**MODIFICATION REQUEST:
Homebush Bay Bridge Modification 1
Homebush Bay, between Wentworth
Point and Rhodes
(MP10_0192 MOD 1)**

Modification to bridge design

Director-General's
Environmental Assessment Report
Section 75W of the
Environmental Planning and Assessment Act 1979

February 2014

CANADA BAY RETAIL & RESIDENTIAL ON SITE 3D - VIEW 3
2012 EA BRIDGE

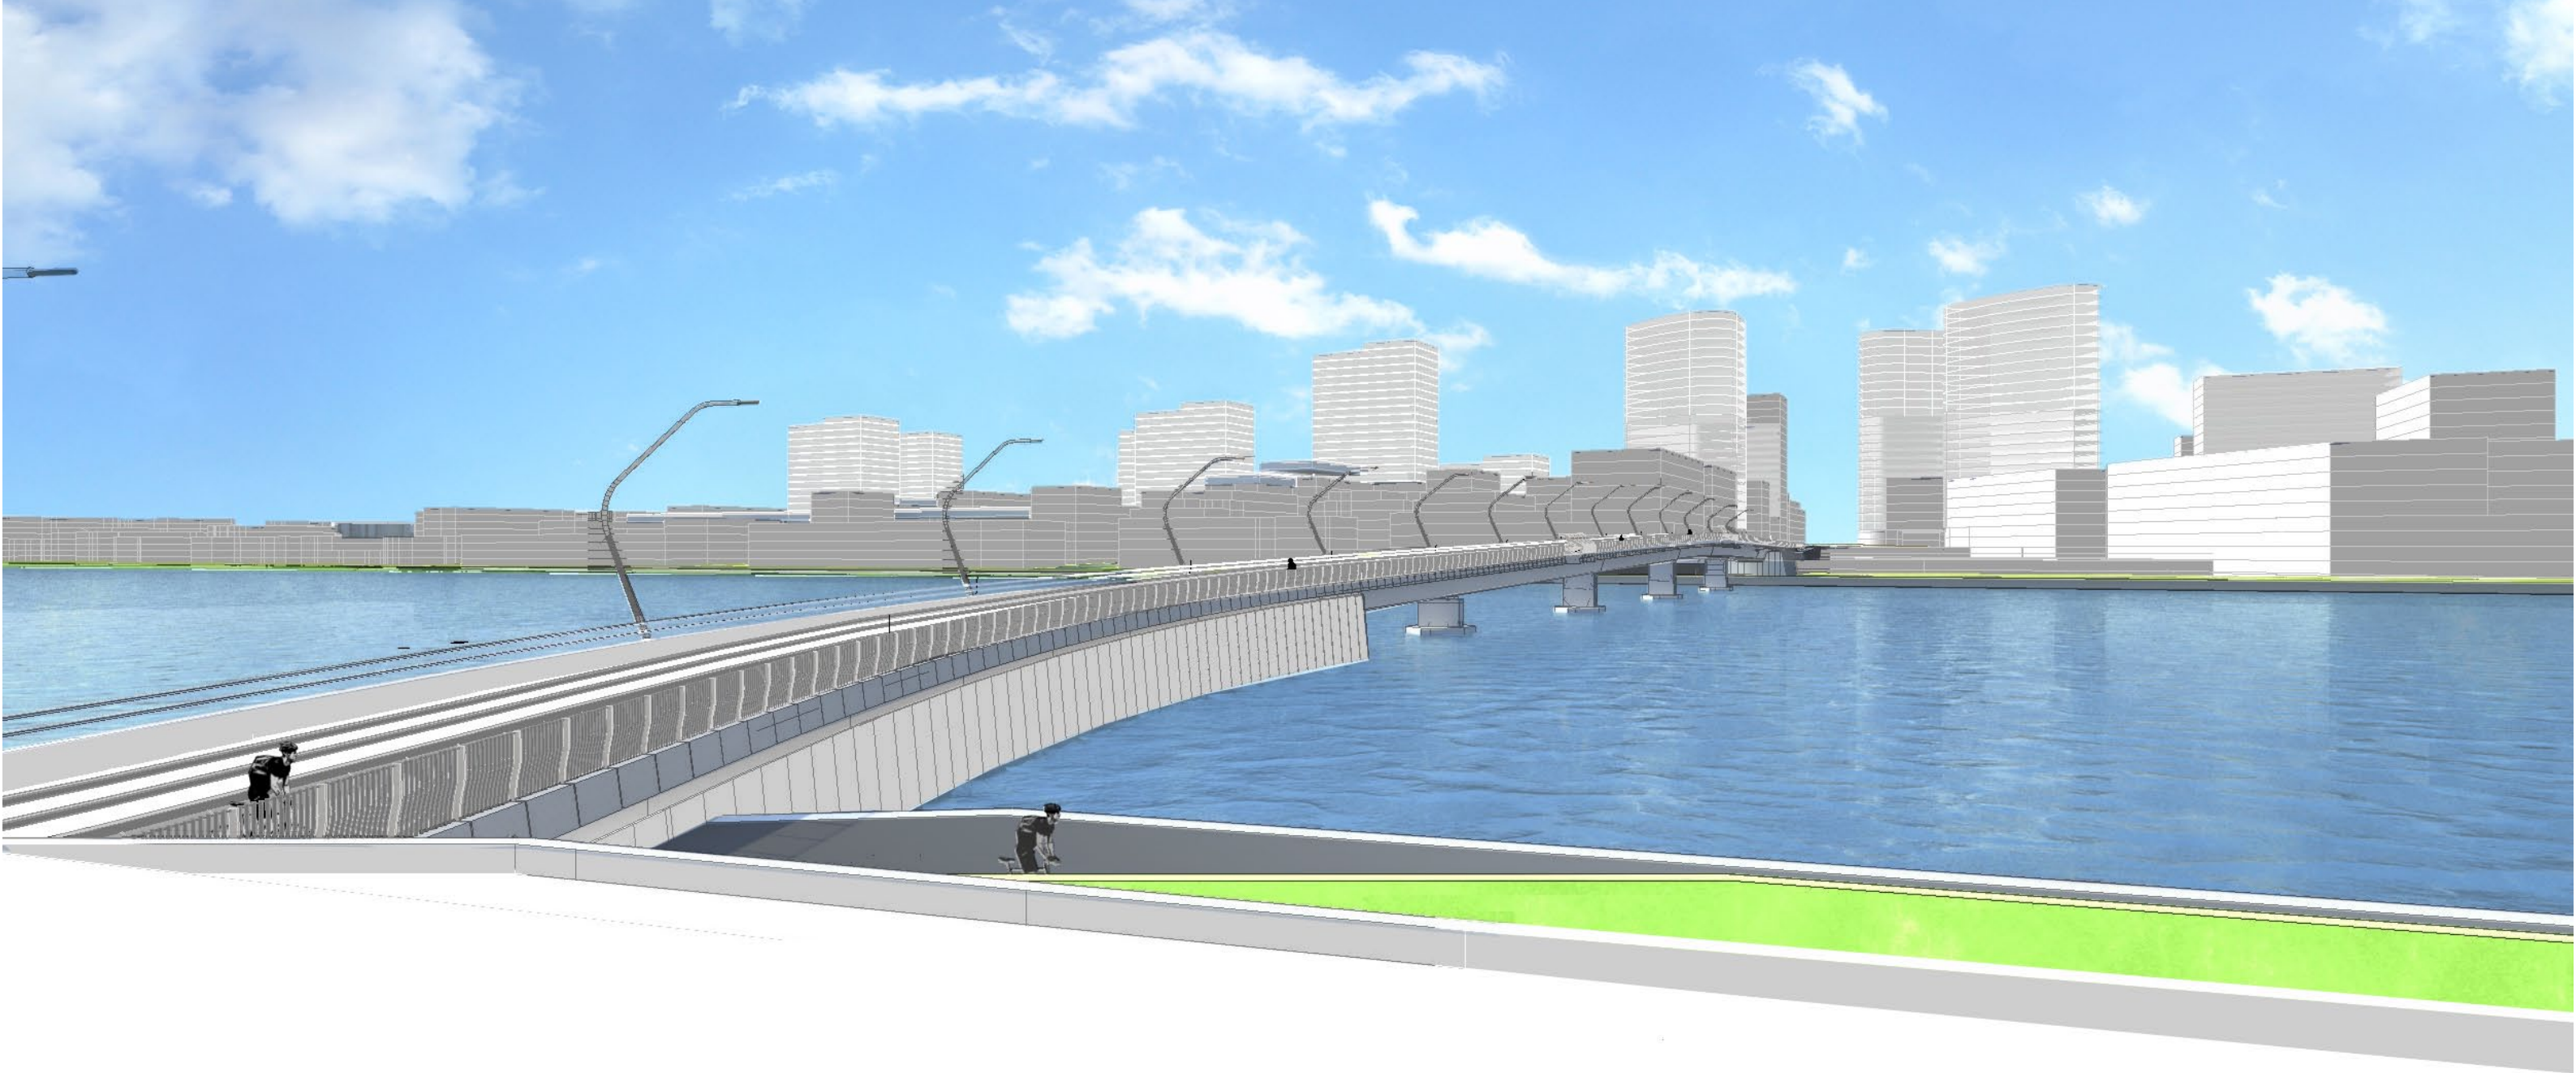
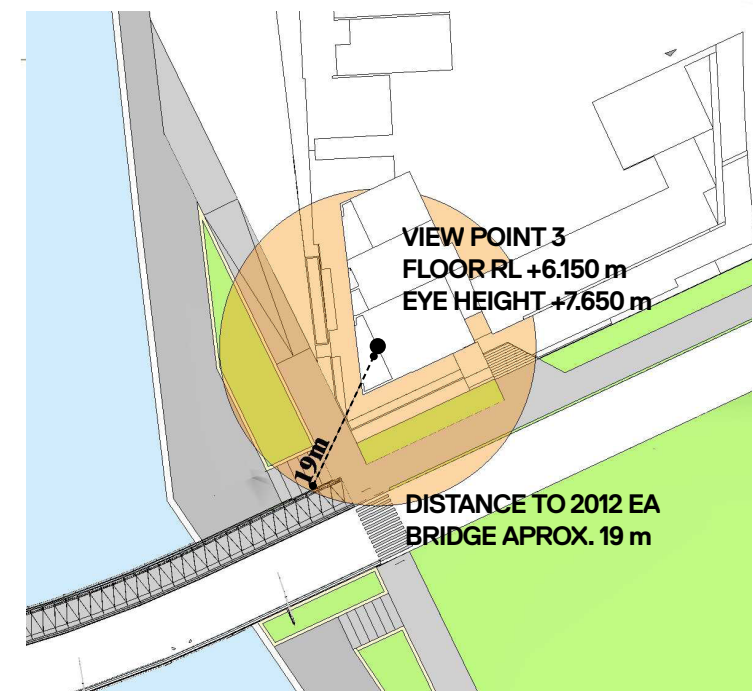
Extent of impact: The proposal affects the views from the south facing windows and from the terrace. The south facing windows and the south-western view from the terrace will retain views of the western shore of Homebush Bay and the Olympic Park skyline, but will lose views of foreground water. Views to the west from the living room and the terrace lose some of the far view of the western shore on the southern side of the bridge but gain foreground water. The view from the terrace to the north-west is unchanged. This is an approximately 60 degree plane. Given that the modification does not completely remove water views in any direction, and largely retains the valued views from the living room and terrace, the extent of the impact is considered minor to moderate.

The proposal reduces the views from Unit 1 to the south and south-west, but retains views to the Olympic Park skyline and views to the west and north-west are unchanged. View impacts to Unit 1 are not considered to be unacceptable.
